## Proposed Lake Lothing Third Crossing (TRO10023)

### Associated British Ports (20013261)

#### Responses to ExA's Written Questions – 8 January 2019

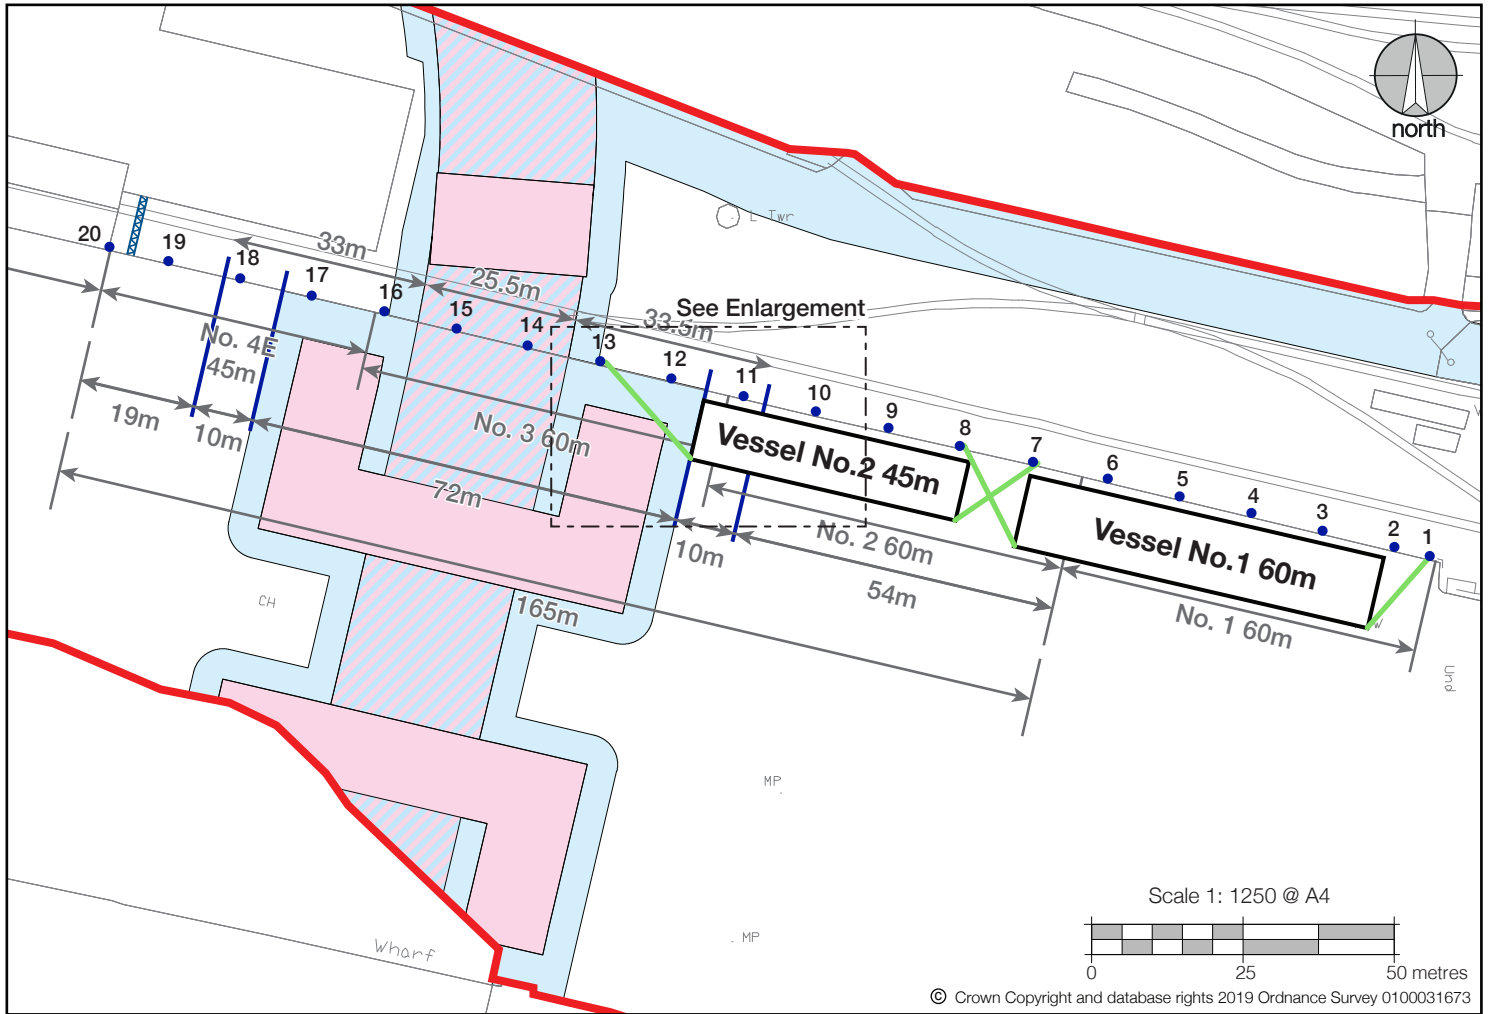
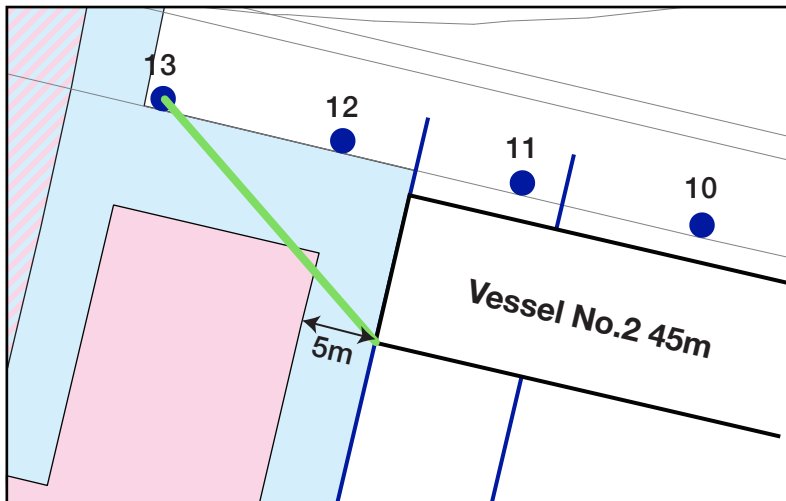
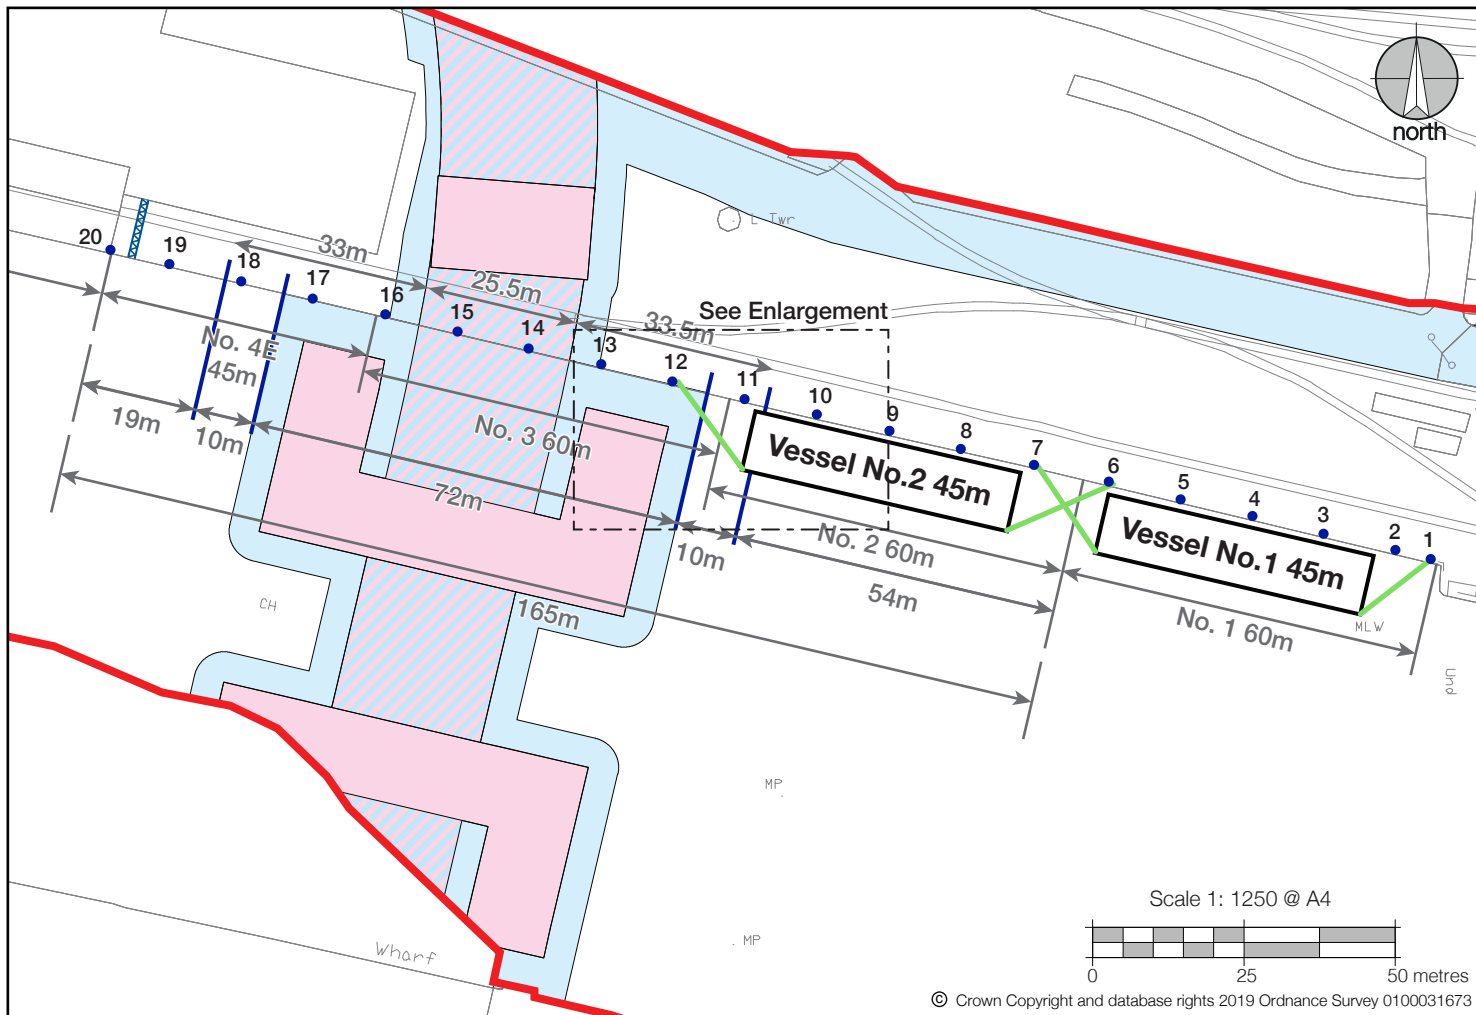
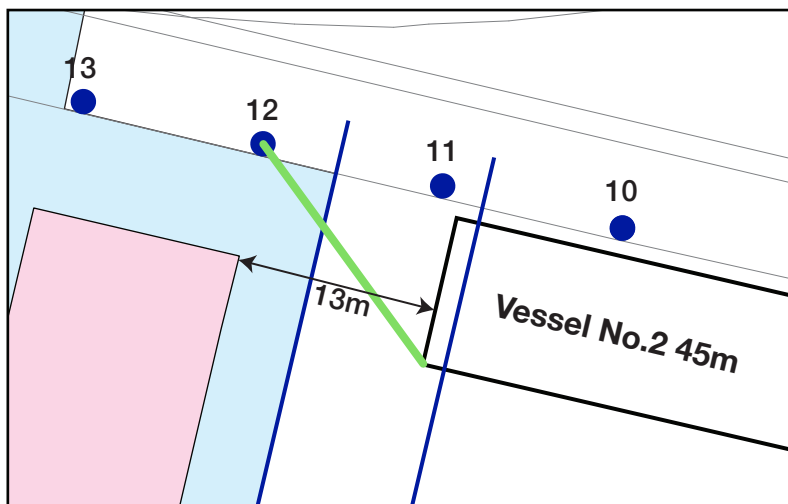
2.17	<p><b><i>If the proposed bridge is constructed will you still be able to use the berth immediately to the west on the north side where your transit shed is located?</i></b></p>	<ul style="list-style-type: none"> <li>• No. The remaining length of useable quay (at around 19m) will be too short for commercial port operations.</li> <li>• The impact of the proposed LLTC is, however, significantly greater than just this and differs between the construction and operation of the proposed new bridge.</li> <li>• <b>Construction:</b> During construction, the Applicant has indicated a need to acquire temporary possession rights over approximately 420m of Lake Lothing, all of which is bounded to the north by the Port's berths. Thus, the potential exists to deprive the Port of access to/utility of some or all of: <ul style="list-style-type: none"> <li>- The 420m of quays immediately to the north of Lake Lothing, as well as;</li> <li>- A further approx. 500m of quays (comprising North Quay 6 (part), 7E and 7W and the entirety of Shell Quay) upstream of the westernmost limit of the temporary possession rights sought.</li> </ul> </li> <li>• The promotor has also indicated that it will need to block the entire width of Lake Lothing whilst the LLTC is being put in place and commissioned. ABP notes that no formal temporal restrictions to limit this closure to the minimum are included in the dDCO, apart from a requirement that the Applicant use its best endeavours to minimise obstruction, delay or interference to vessels, and to only close as much of Lake Lothing as is</li> </ul>
